From: Laura Gibbons <Laura.Gibbons@arun.gov.uk>
Sent: 01 March 2022 10:28
To: Planning.Responses <Planning.Responses@arun.gov.uk>
Cc: Simon Davis <Simon.Davis@arun.gov.uk>
Subject: RE: Planning Re-Consultation on: Y/185/21/DOC

Application No: Y/185/21/DOC

Site Address: Land East of Drove Lane Yapton BN18 0EB

Description of Works: Approval of details reserved by condition imposed under reference Y/92/17/OUT relating to Condition Nos 9 - surface water drainage, 10 -

CLIENT BARRATT DAVID WILSON HOMES			DWG. TITLE TREE PIT DETAIL IN POS IN PROXIMITY TO LINED ATTENUATION FEATURE			
PURPOSE OF ISSUE PLANNING STAGE						
SITE YAPTON, DROVE LANE						
DRG BY AJW	CHECKED JBA	AUTH'D JBA	SCALE 1:20@A3	DATE FEB 2022	DWG NO. JBA 19/291 -DT4	REV. .

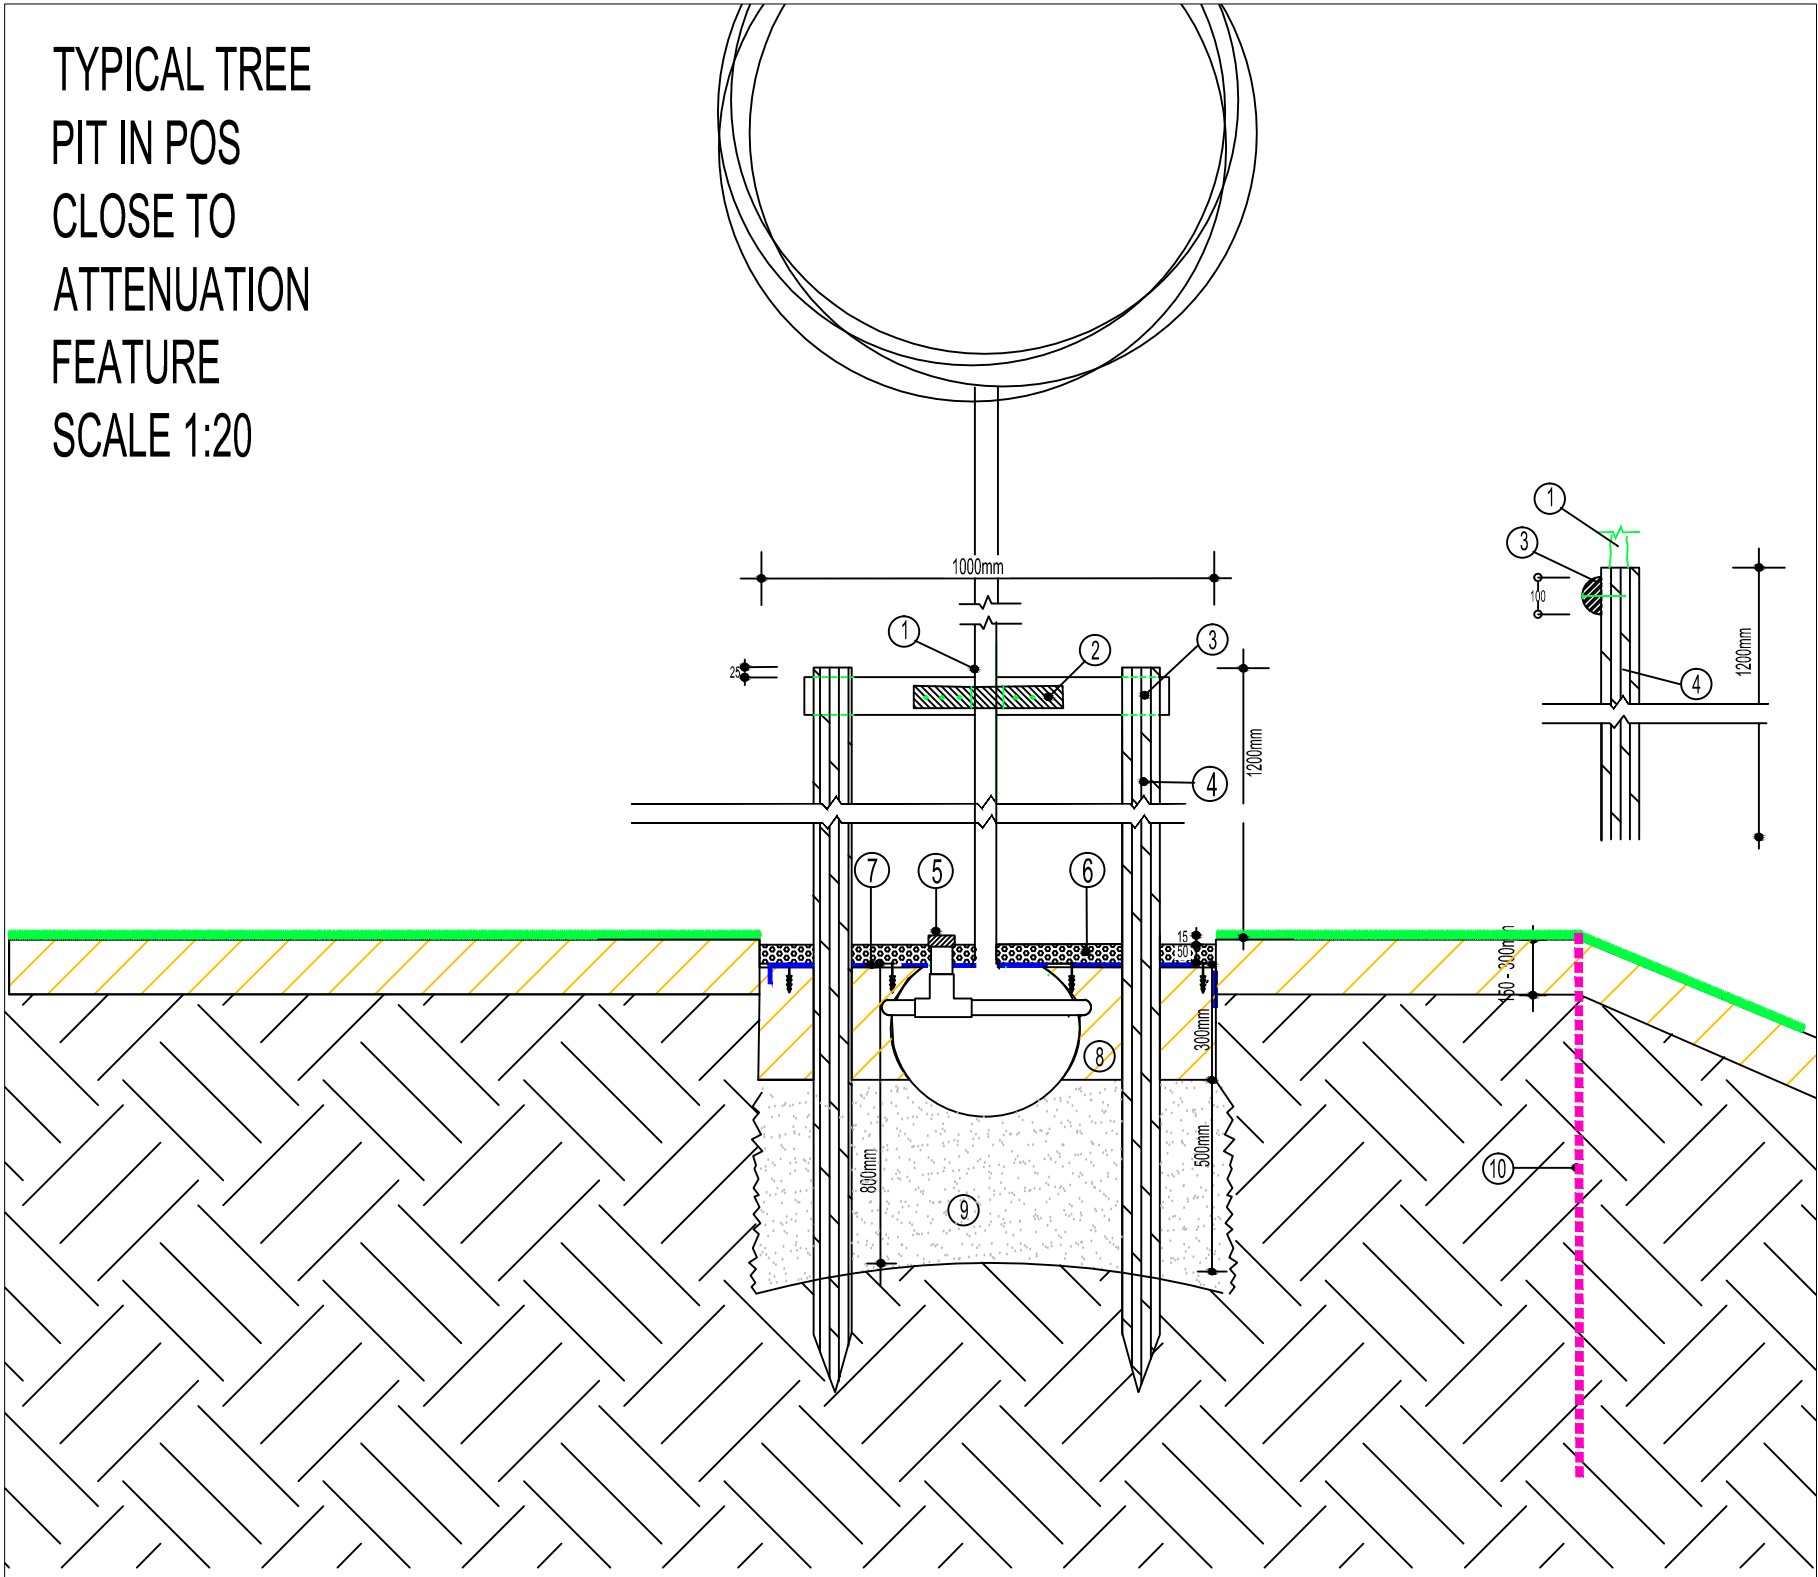
We also note that our previous comments were "We note that some root barriers are proposed, however we do not generally support these." The revised landscaping plans show more root barriers. We would reiterate that we do not generally support these, and root barriers should be a last resort, with tree species and positions first reviewed. The applicant referring to our acceptance of their use on another site is not entirely accurate, root barriers were accepted in limited locations after the majority of conflicting trees were repositioned, those few which could not be suitably repositioned were then allowed to have root barriers. The use of root barriers can negatively impact upon the health of trees, and their success in protecting drainage features is heavily dependant upon the depths of barriers being correct and the barriers being installed appropriately.
